**City of Albuquerque
Stormwater Construction Site
Inspection Report**

Project Name and Location	<u>Chiti's Gibson at University</u>	ESC PERMIT #	
Site Contact Name & Agency	<u>Karin Moynihan Buffalo Construction, INC</u>	Contact Phone #	<u>423-847-7014</u>
Date of Inspection	<u>8-25-15</u>	Start/End Time	<u>9:55/10:00</u>
Inspector Name, COA Dept.	<u>Curtis Cherne, Stormwater Quality</u>		
Inspector Phone / E-mail	<u>505-924-3420/ccherne@cabq.gov</u>		
Inspector Qualifications	<u>Stormwater USA</u>		
Describe Present Phase of Construction	<u>Site grade, curb and gutter construction, bldg now complete</u>

From: Cherne, Curtis
Sent: Friday, August 07, 2015 12:40 PM
To: kevin.moynihan@buffaloconstruction.com; rachel.steele@buffaloconstruction.com
Subject: Chili's on Gibson SWPPP follow-up inspection
Attachments: concrete-washout-center.jpg; concrete-washout-gibson.jpg; concrete-washout-se-corner.jpg

From: Cherne, Curtis
Sent: Thursday, July 30, 2015 11:47 AM
To: 'kevin.moynihan@buffaloconstruciton.com'; 'rachel.steele@buffaloconsgrudition.com'
Subject: SWPPP inspection Chili's 1700 Miles Rd
Attachments: clogged-inlet.jpg; culvert-wattle.jpg; swept-street.jpg; trash.jpg

TEMPORARY EROSION CONTROL
AND SEDIMENTATION PLAN

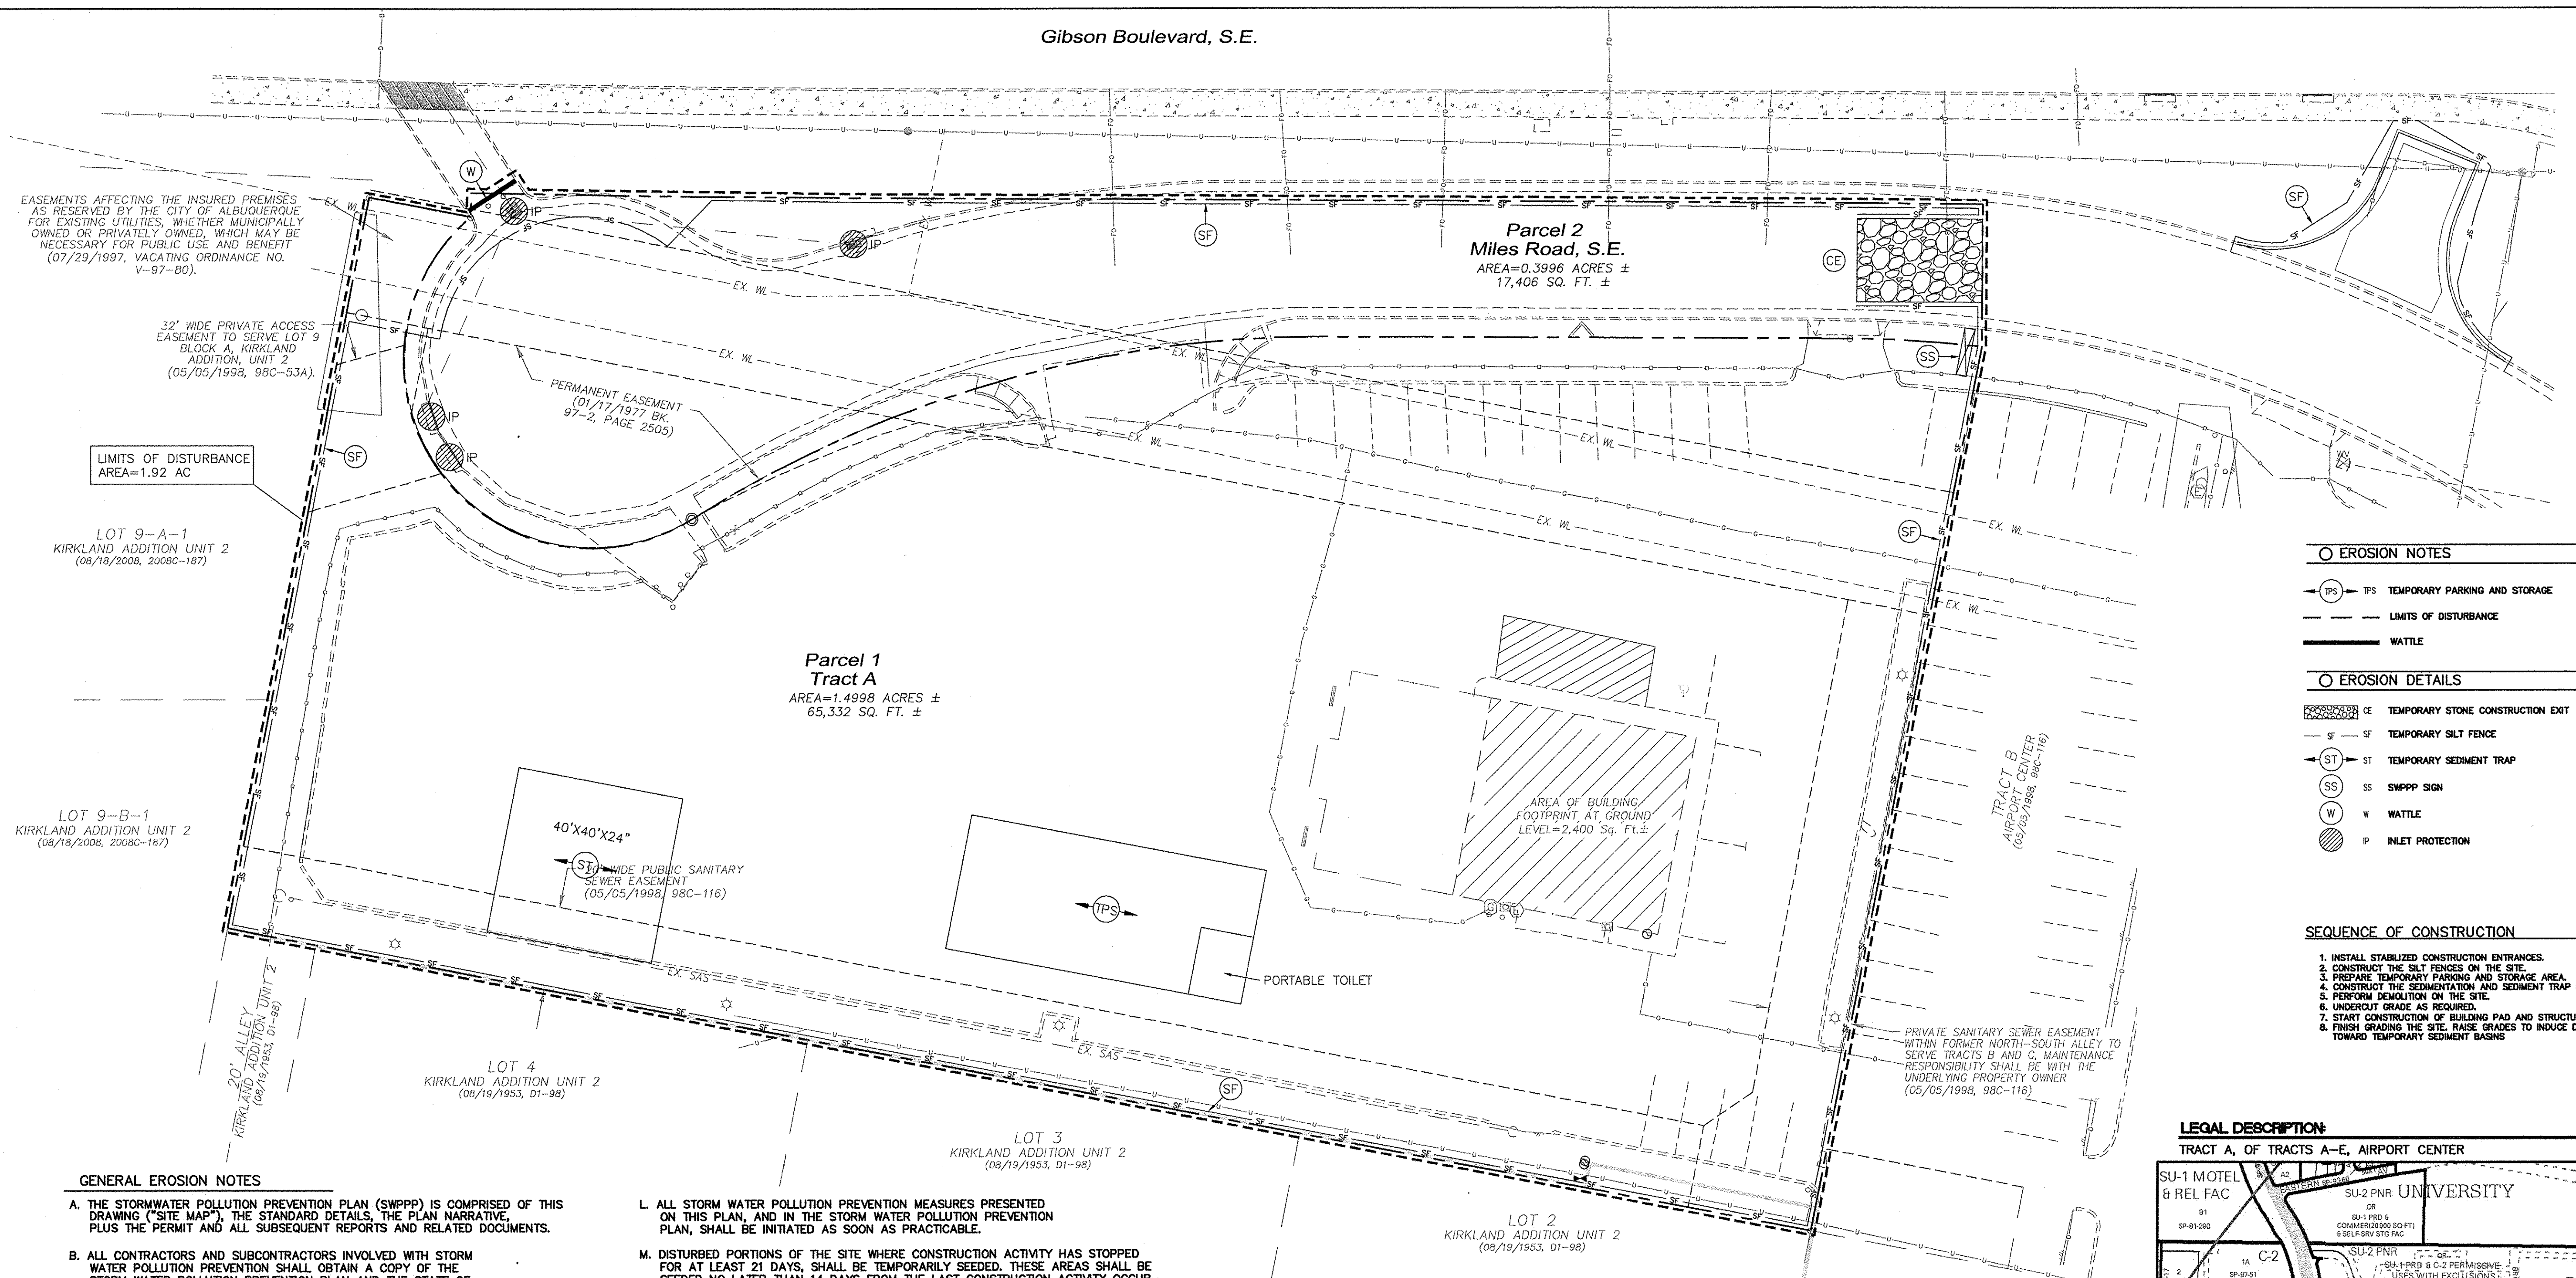
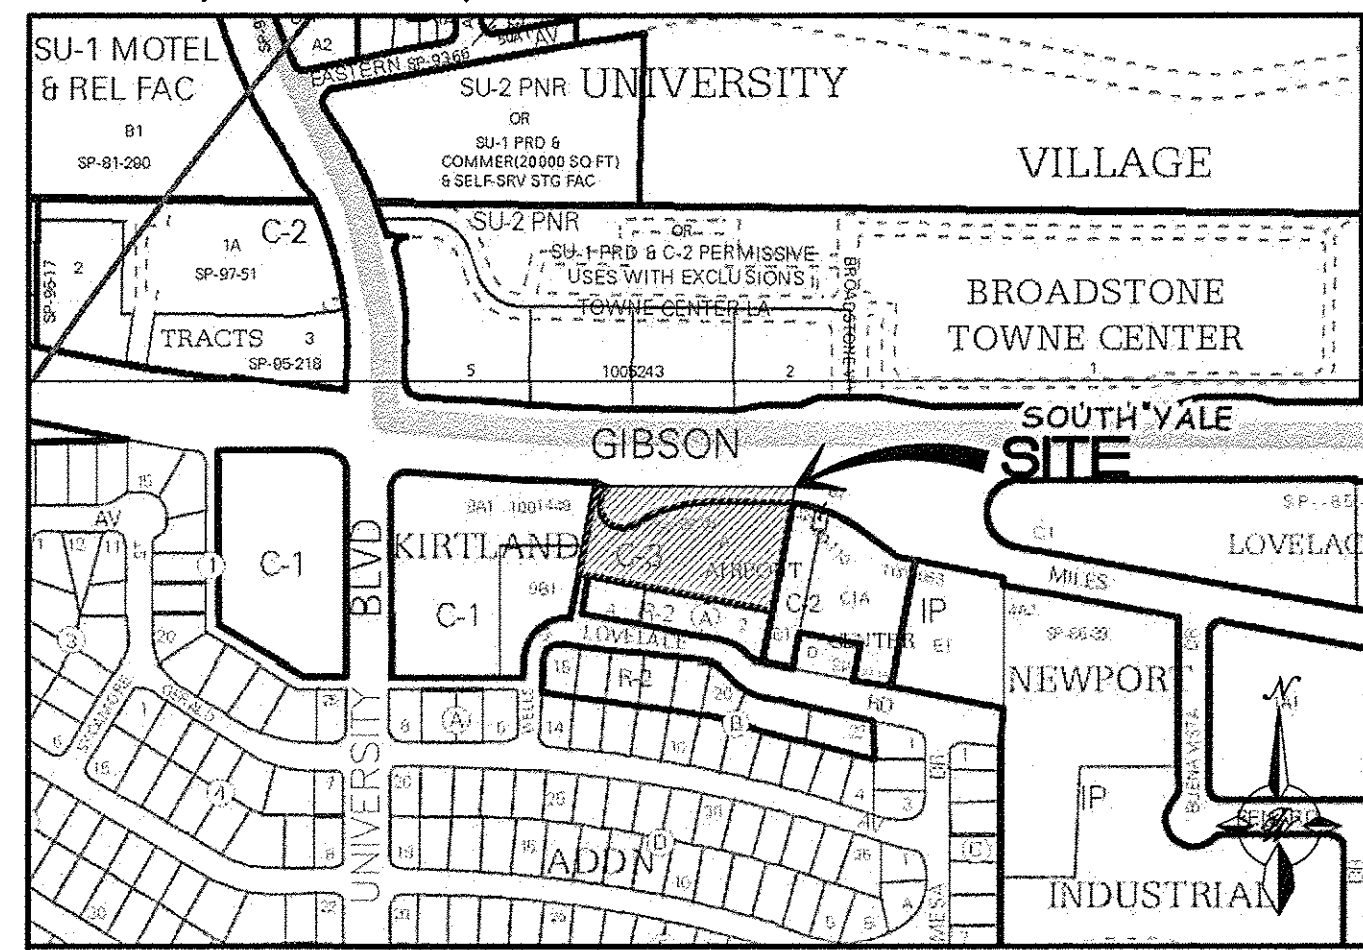
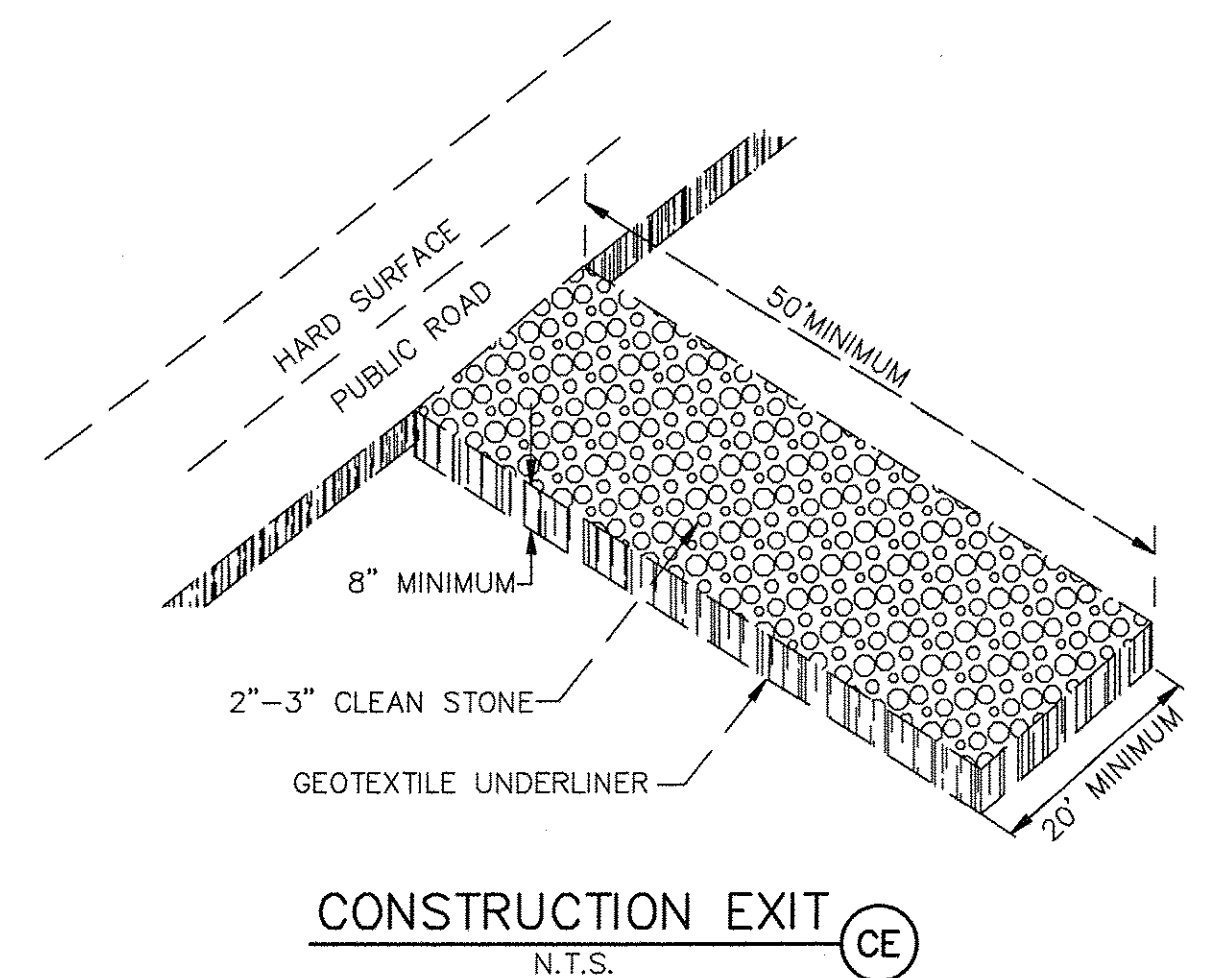
1. The inlet just upstream of the channel was not visible. It is difficult to tell if it is totally plugged or protected. The approved plan shows inlet protection around the inlet. This is a better way to go than covering it as it could still except some drainage. I want to see the inlet during my follow-up visit.
2. The wattle at the sidewalk culverts was not covering the western culvert and the culvert is plugged.
3. There was some trash along the northern edge of the property.

As mentioned onsite, the above listed items are to be mitigated within 7 days.
